OFFICIAL NOTIFICATION OF DECISION

November 18, 2021

Project #2021-005426
SI-2021-01685 Site Plan- Major Amendment
RZ-2021-00045 Zoning Map Amendment (Zone Change)

Consensus Planning Inc., agent for SMI-ABQ Assets LLC, requests a zoning map amendment from NR-LM to NR-SU and Site Improvement for all or a portion of the South 100 Feet of the North 330 Feet of West ½ of Tract J, of Cole's Industrial Subdivision No. 2, located at 3300 Vassar between Candelaria Rd NE and Aztec Rd NE, approximately 0.5 acre (G-16-Z)

1 REFUSE ENCLOSURE CONCRETE PAD SCALE: 1/4"=1'-0"

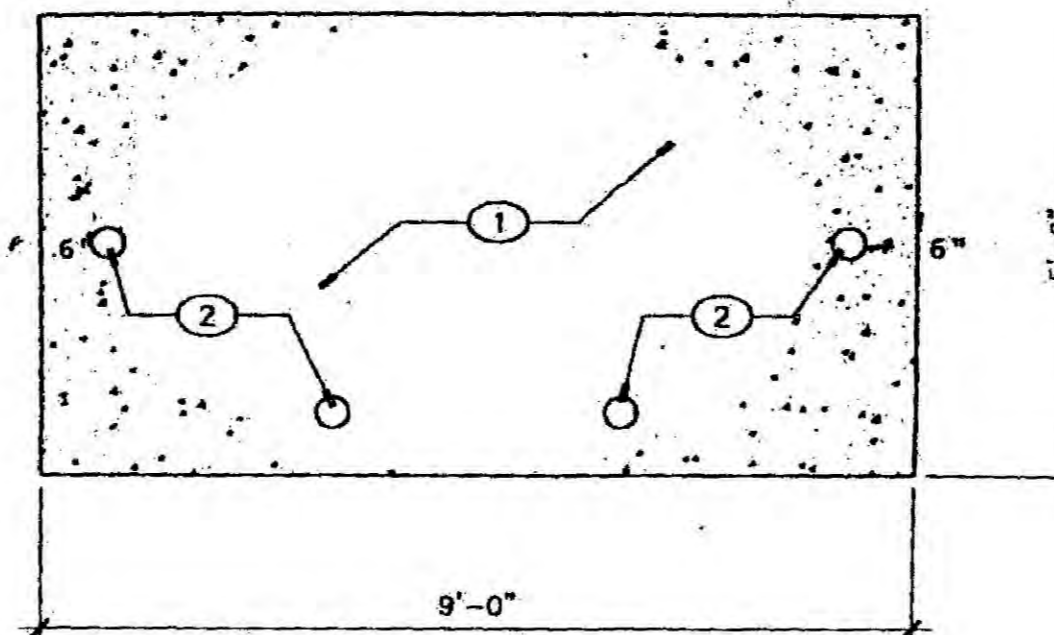
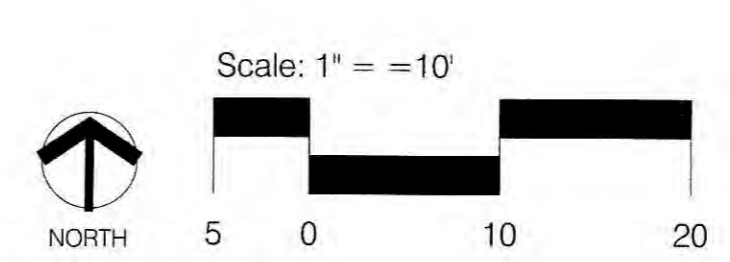
- A. A site plan to scale approved for access will be required by the Solid Waste Department.
- B. The trash enclosure will have to meet City of Albuquerque minimum requirements.

C. An apron to the trash enclosure will be required.

SITE PLAN

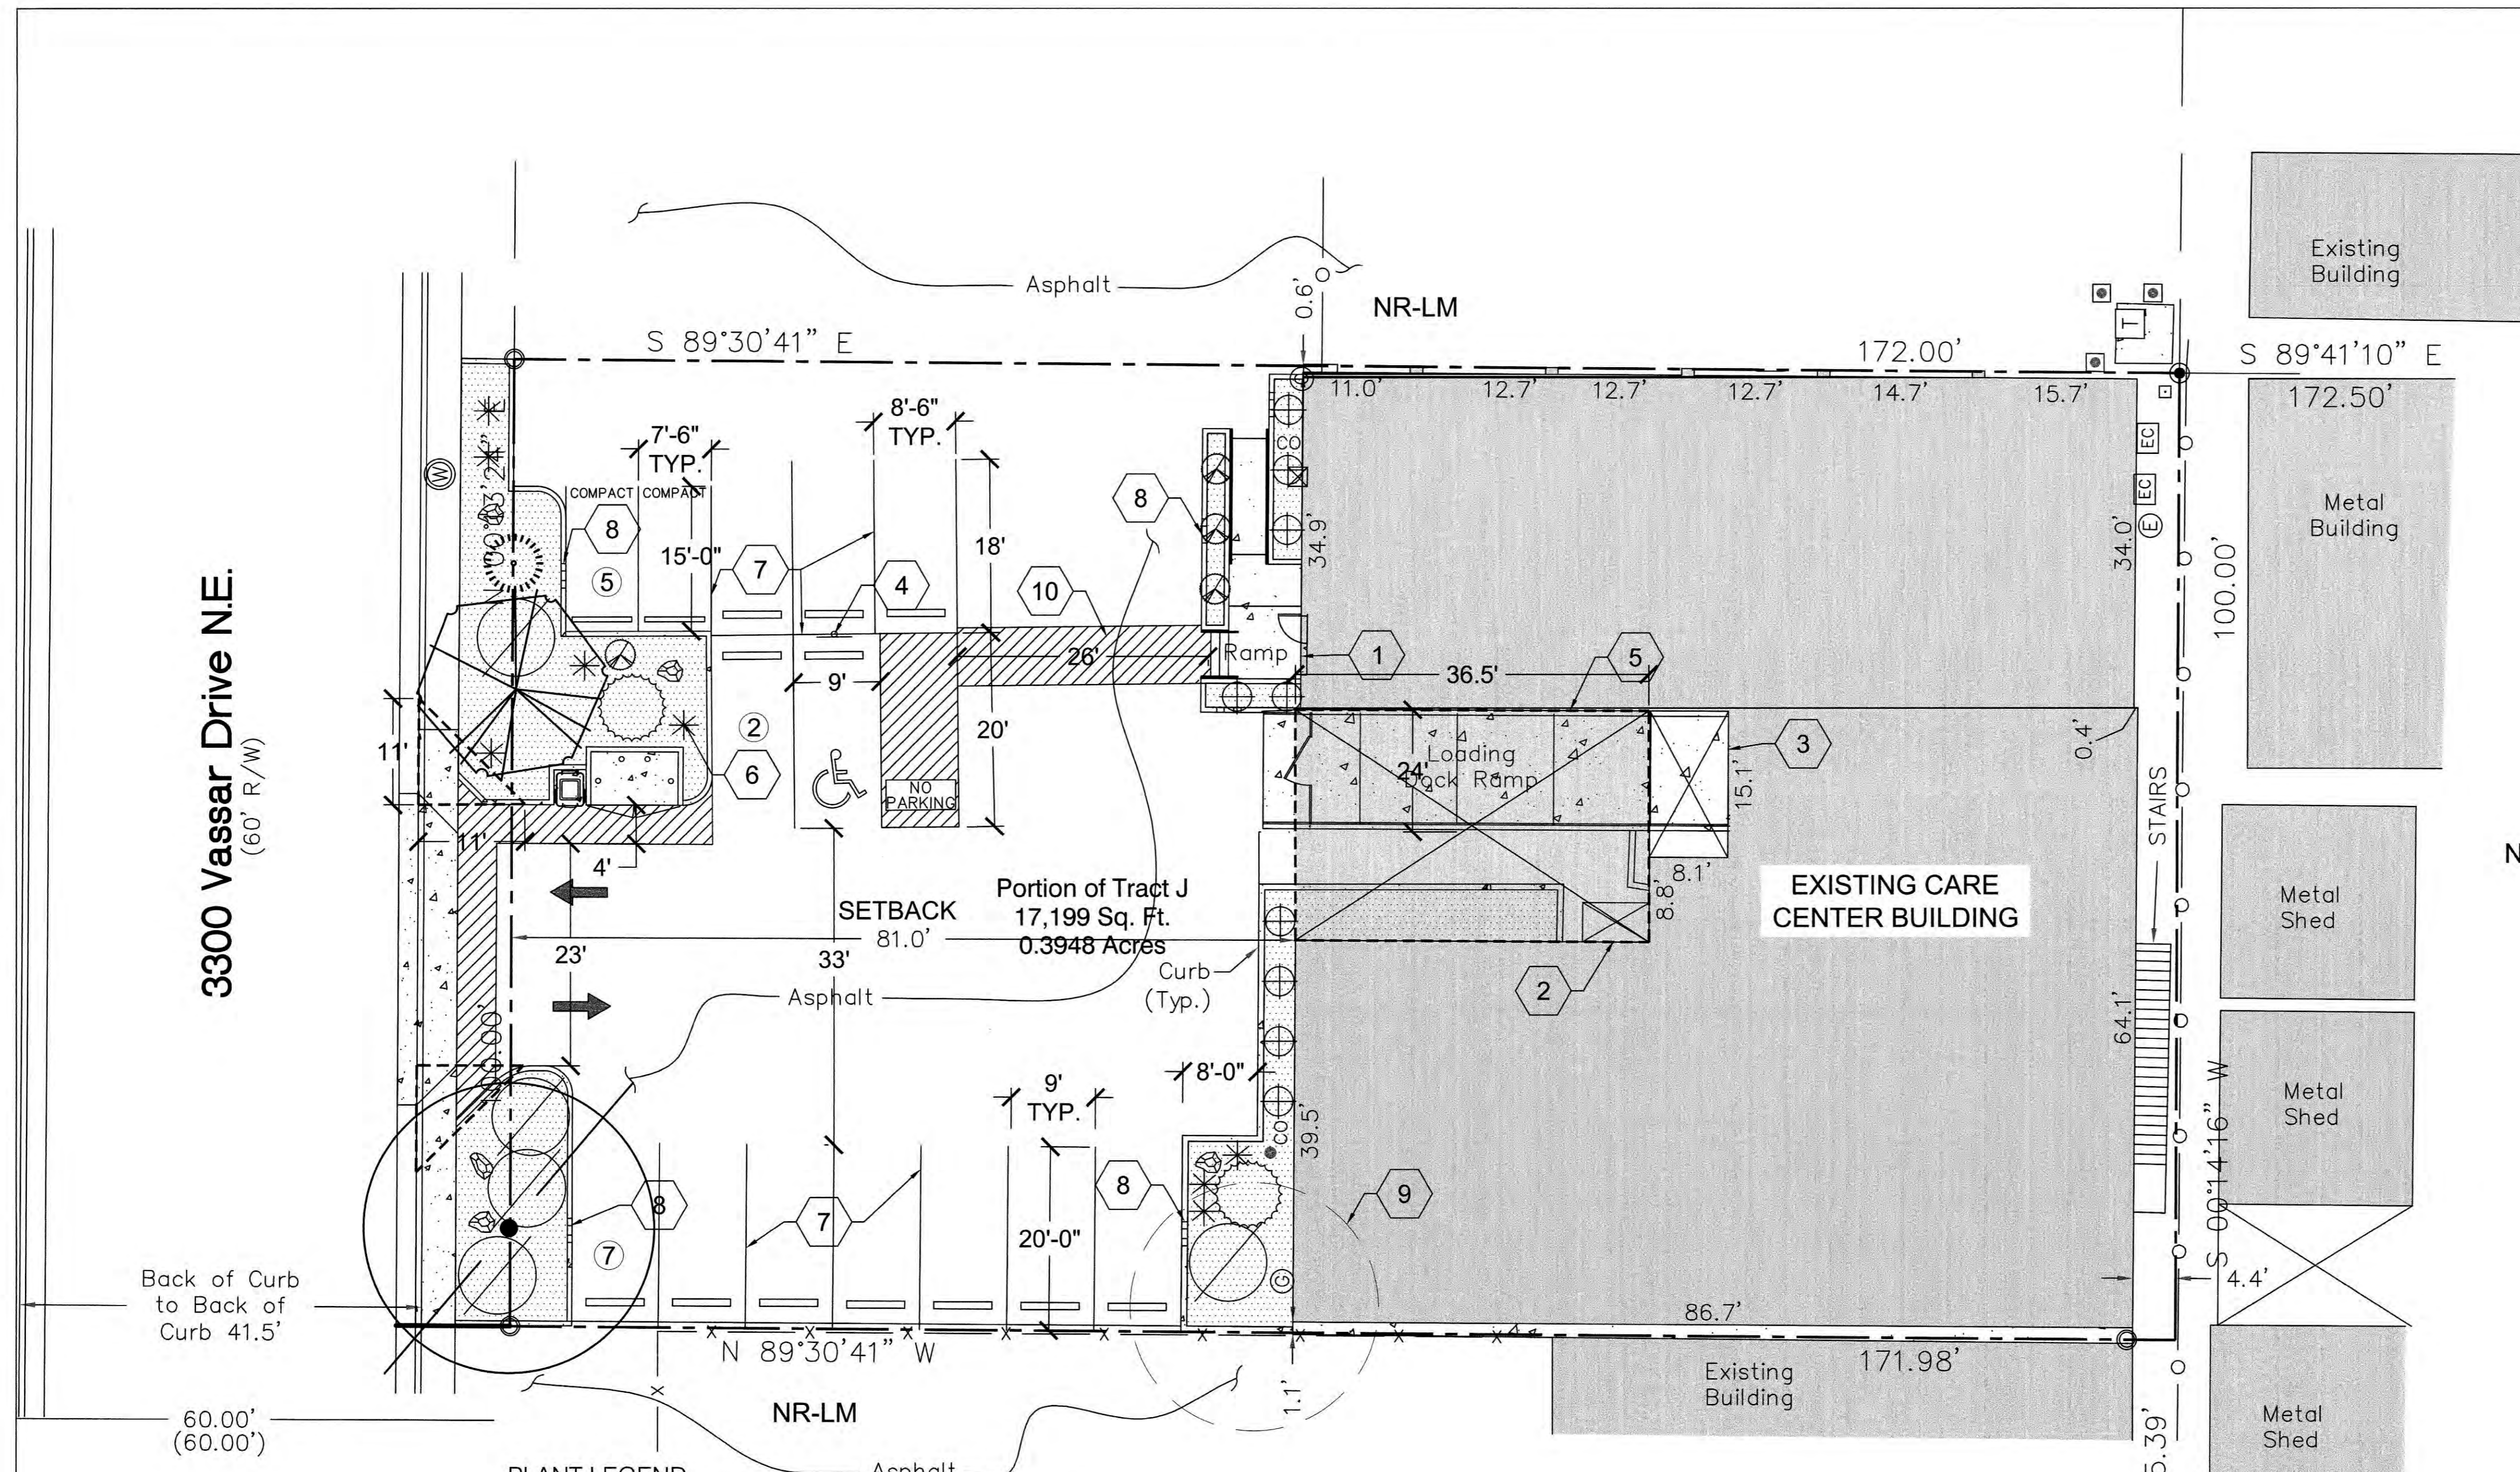
- B. The site plan shall clearly dimension the building footprint.
6. Parking: The site plan shall clearly and correctly dimension parking lot aiseways.

- A. The note regarding depressed landscaped areas shall be removed from sheet one of the site plan, it is only needed on the landscape plan.
- B. The square footage calculations shall be shown per floor, i.e., total square footage for 1st floor and total square footage for 2nd floor.
- C. The refuse enclosure shall incorporate at least 1 of the primary colors and materials of the existing building pursuant to IDO section 5-6(G)(3)(e).
- D. The total square footage for the proposed porch cover shall be accurately shown on the site plan. Staff found that 44.2' x 23.9' is equal to 1,056.38 square feet, which is more than 1,000 square feet. The site plan shows the proposed porch at under 1,000 square feet.
- E. The proposed porch cover shall be clearly dimensioned.

**CARE CENTER (MORTUARY & CREMATORIUM)
3300 VASSAR DRIVE NE
LANDSCAPE PLAN**

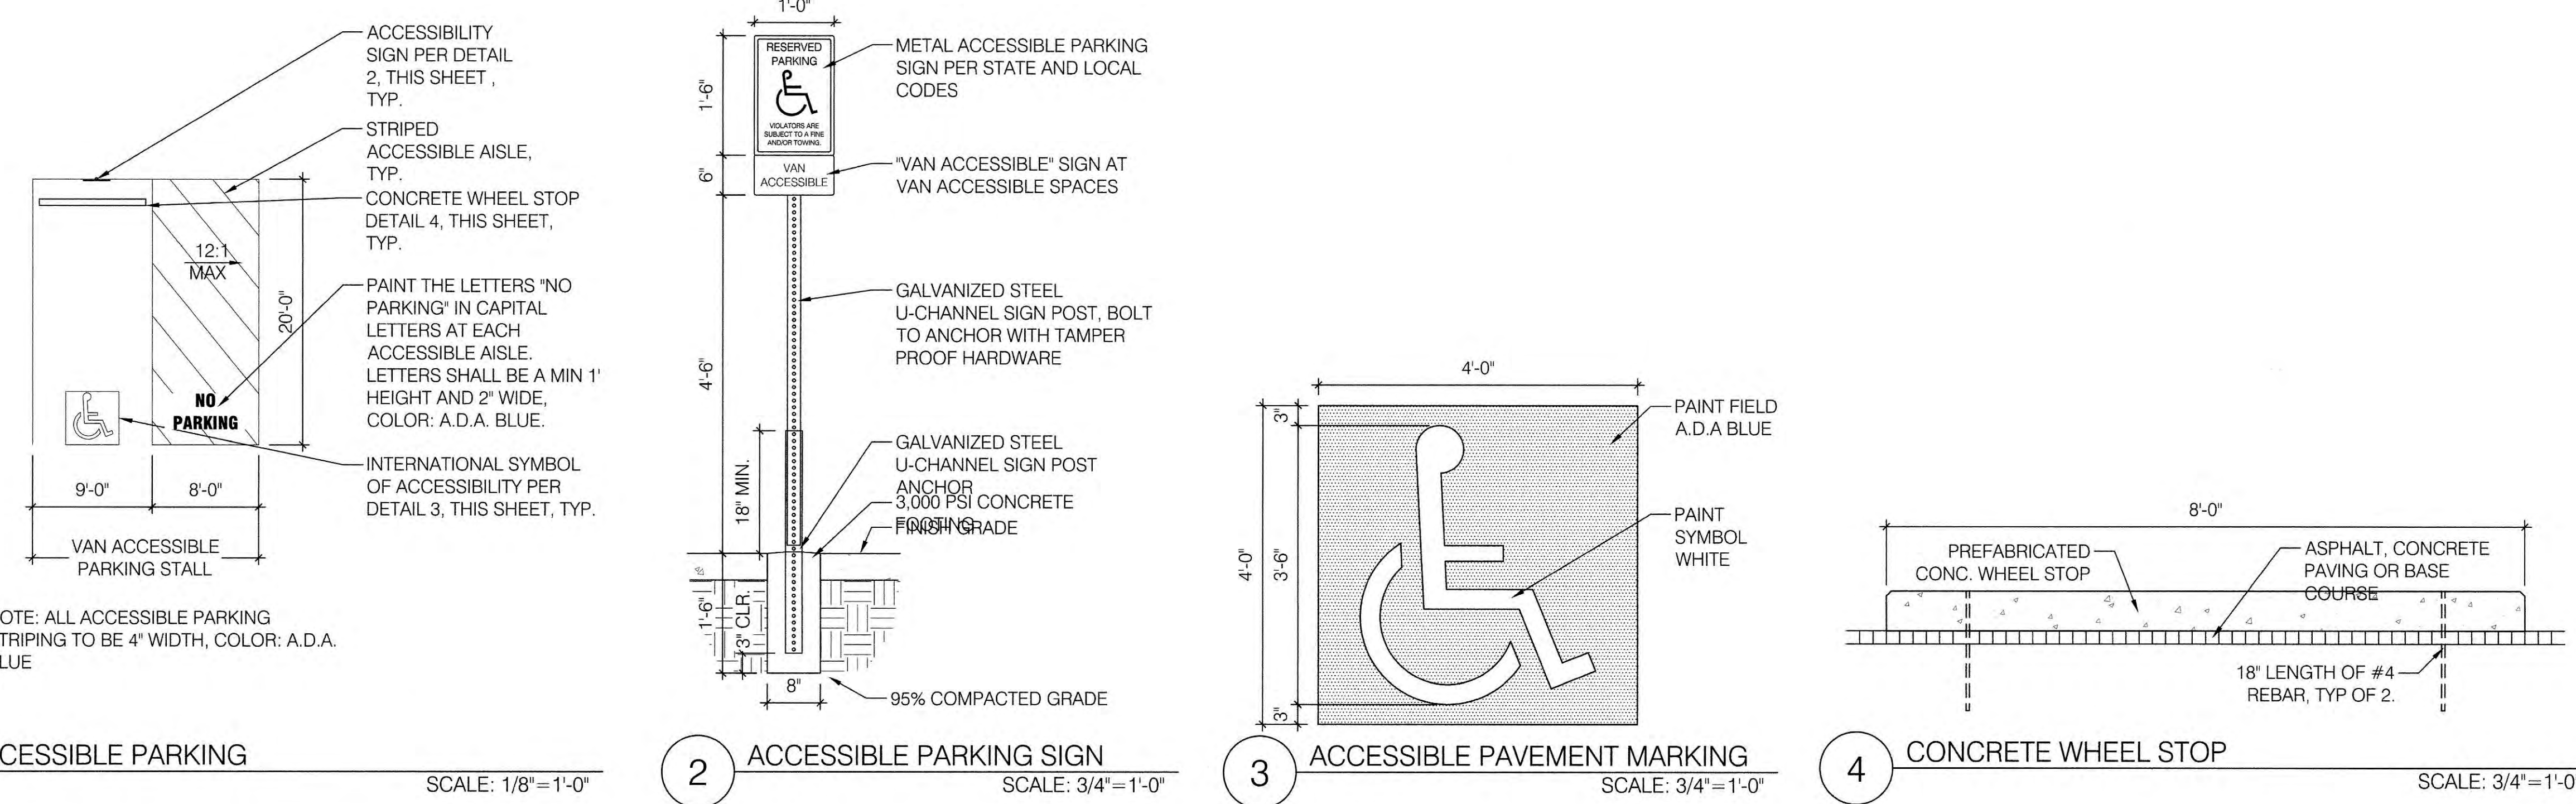
7. Landscaping - General:
 - A. Landscape calculations shall be updated to reflect the accurate overall lot size.
 - B. The site plan shall show which IDO provision was used to determine the appropriate landscaped area, i.e., pursuant to IDO subsection 5-6(C)(2) the minimum landscaped area shall be 15% of the net lot area.

- C. Calculations shall demonstrate how the net lot size was determined
 - D. A note shall be added stating that requirements under IDO section 5-6(C)(10) – Planting Near Utilities shall be met.

- E. The note regarding depressed areas shall add the relevant IDO citation, IDO section 5-6(C)(13) – Stormwater Management.
 - F. The plant list shall be updated to clarify that only female Buffalo Juniper shall be used.

- G. No turf is shown on the landscape plan, language discussing the amount of watering for turf shall be removed, or the turf shall be clearly shown on the landscape plan.

D. Landscape plan – The proposed Urbanite Ash (tree) will have to be relocated. It cannot overhang the trash enclosure.

B2 WEST ELEVATION

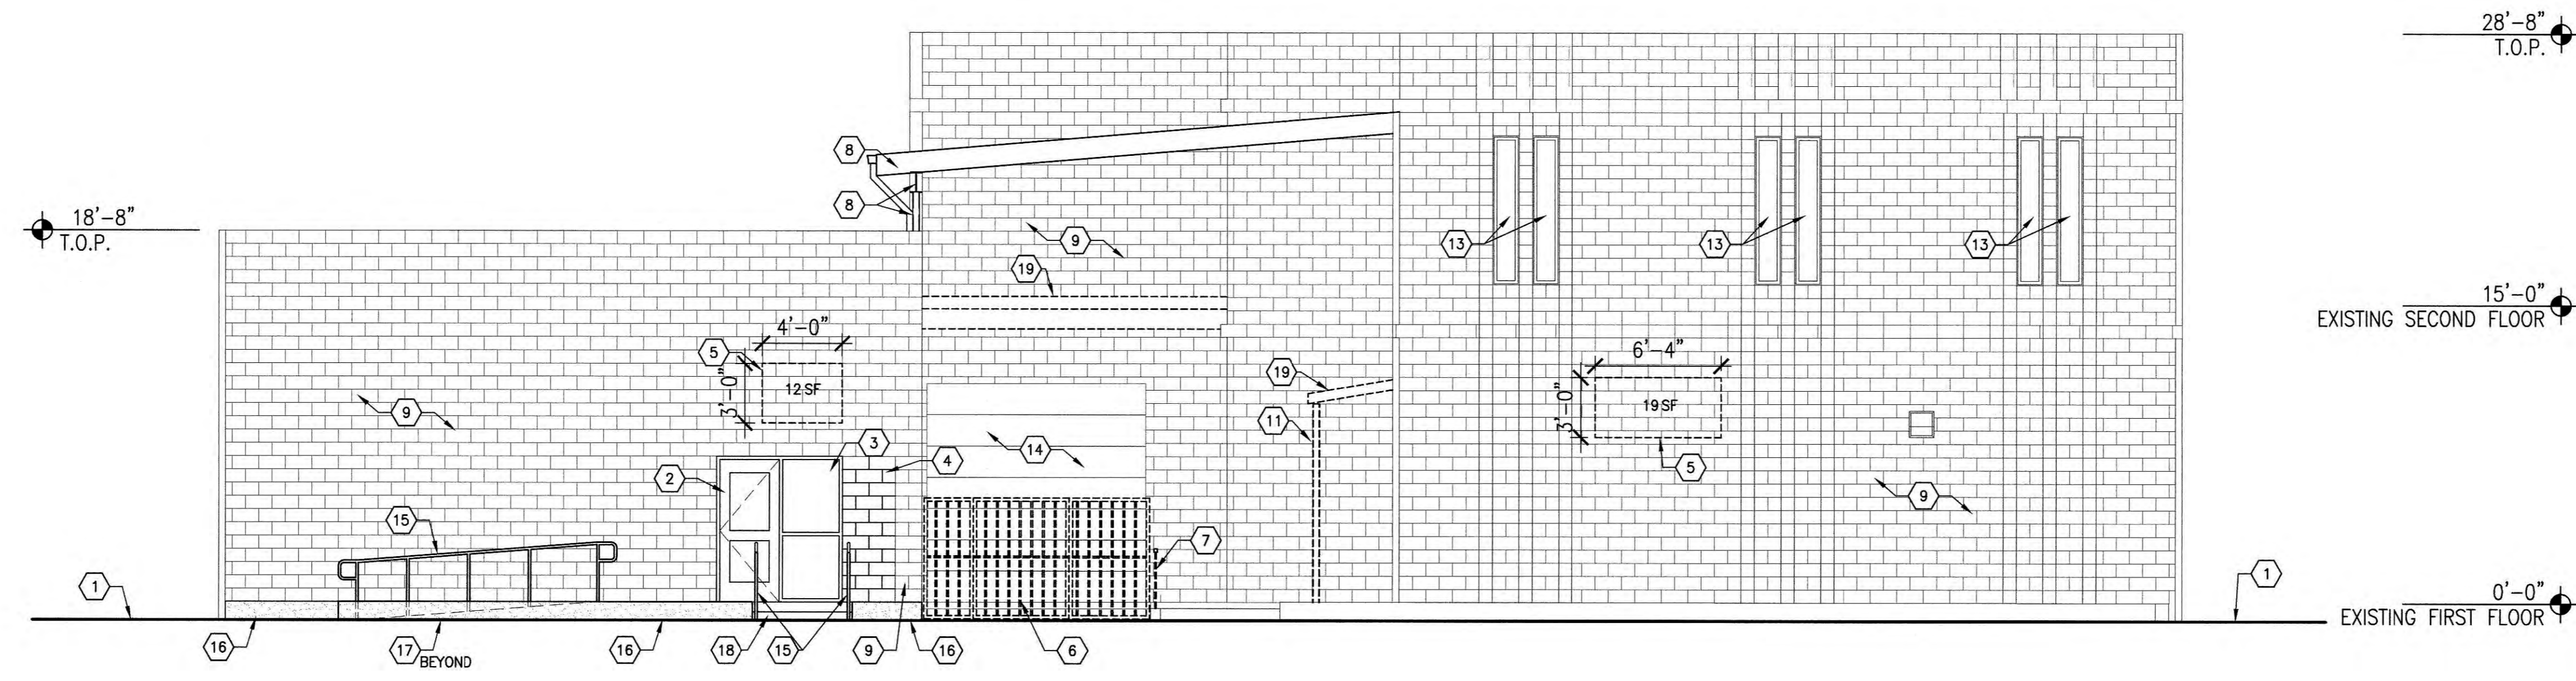
- A. Complete elevation drawings shall be provided, to include any intended changes to the façade as part of the proposed tenant improvements.
- B. The proposed porch cover shall be shown on the west elevation, and any other relevant views.
- C. Accurate building heights shall be shown on all elevations to determine compliance with proposed dimensional standards pursuant to IDO section 5-1(E)(2)(b) – Dimensional Standards, NR-SU Zone District.
- D. Building color and materials shall be clearly identified.
- E. Pursuant to IDO section 5-6(G)(1) – Screening of Mechanical Equipment, proposed screening for new and existing mechanical equipment shall be clearly shown on the elevation drawings.
- F. Pursuant to IDO table 5-12-2, all signage for NR-SU is per approved plan. Proposed signage shall be shown on relevant elevation drawing for the EPC's review, and to establish signage standards.
